KITTITAS COUNTY

MEMORANDUM

TO: All Staff
FROM: Public Works Plan Review Team
DATE: April 20th, 2023
SUBJECT: BL-23-00004 Dunford Barn

DUNFORD BARN
 PROPOSED RECREATION AREA
 NAME
 PT NW1/4 SEC.3 T19N,R17E & PT SW1/4 SEC.27 & W1/2 SEC.34, T20N,R17E, W.M.
 DRAWING TYPE
 RECORD OF SURVEY
 PARCEL NO. 961865/961866 SCALE: 1"=600'
 MAP I.D. 20-17-34050-0006 ET AL DATE: 04/03/2023
 SHEET 1 OF 2
 SHEETS 2
 PROJECT
 22012

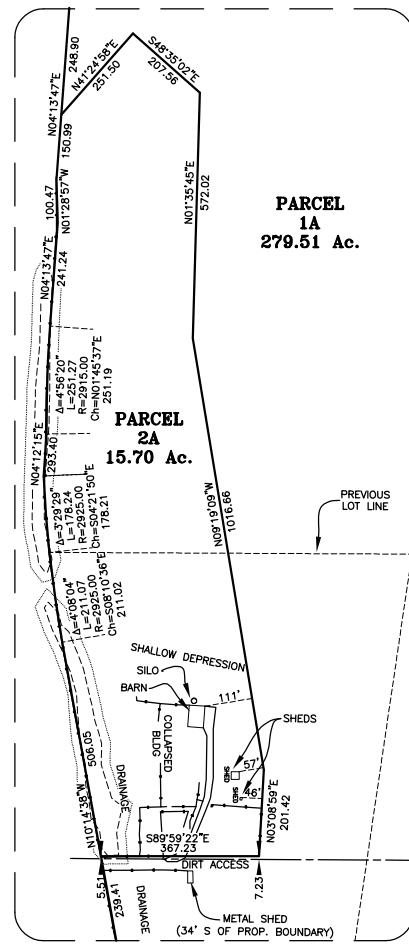
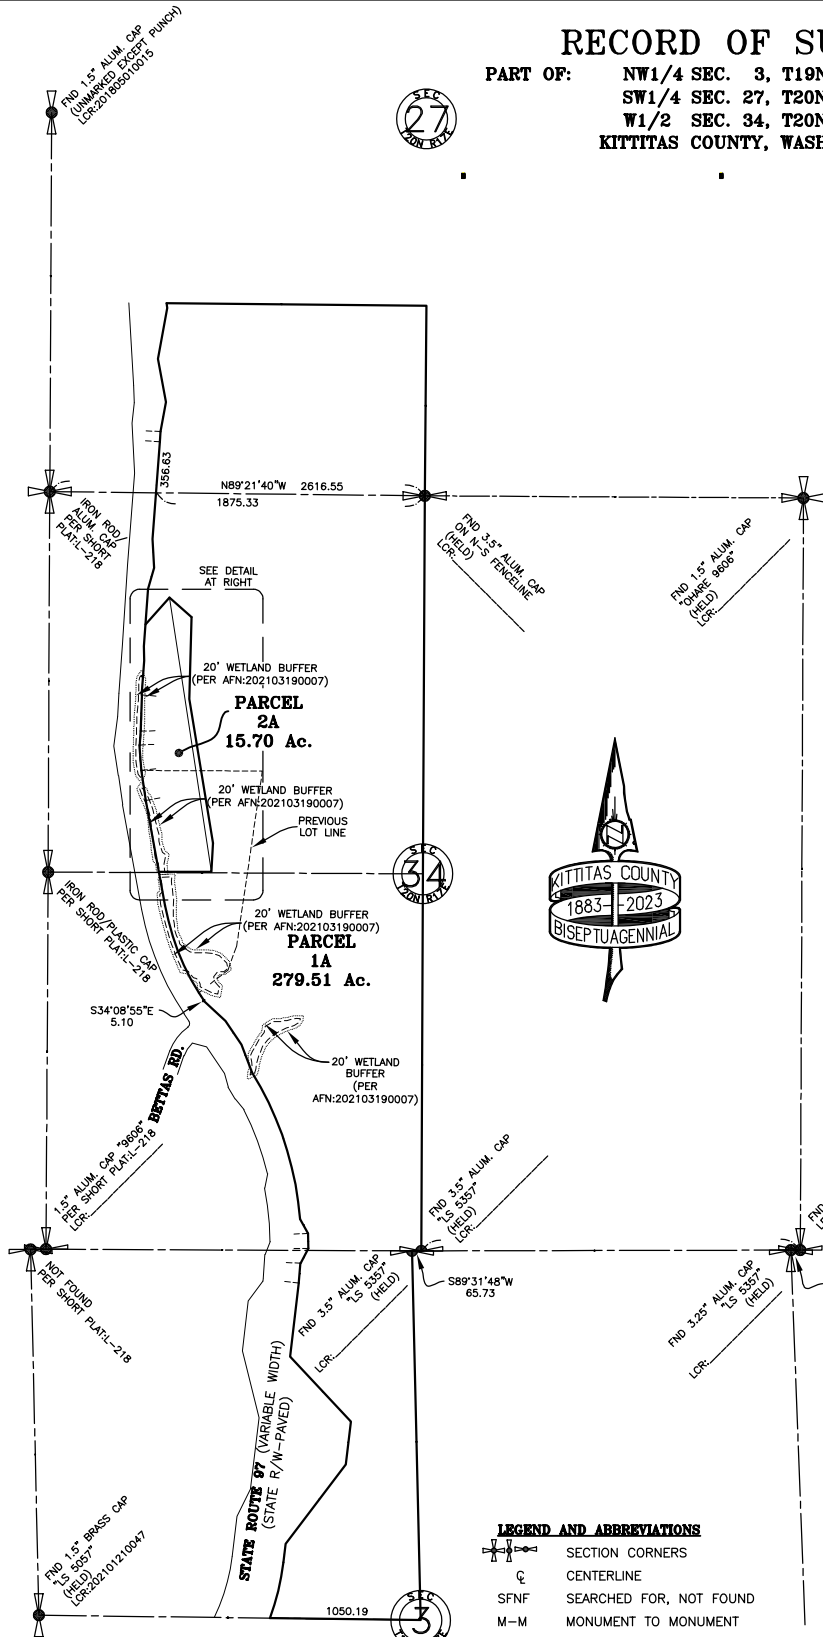
ENGINEERING	No comments. (KH)
SURVEY	<ol style="list-style-type: none"> 1. Title block missing suite number. 2. Missing bearing and distances for Parcel 1A. 3. Missing bearing and distances for section lines. 4. Proposed Legal Description for Parcel 2A should read: "PARCEL 2A PER THAT CERTAIN RECORD OF SURVEY..." (KH)
FLOOD	No comment. (SC)
WATER MITIGATION/ METERING	No comment. (SC)
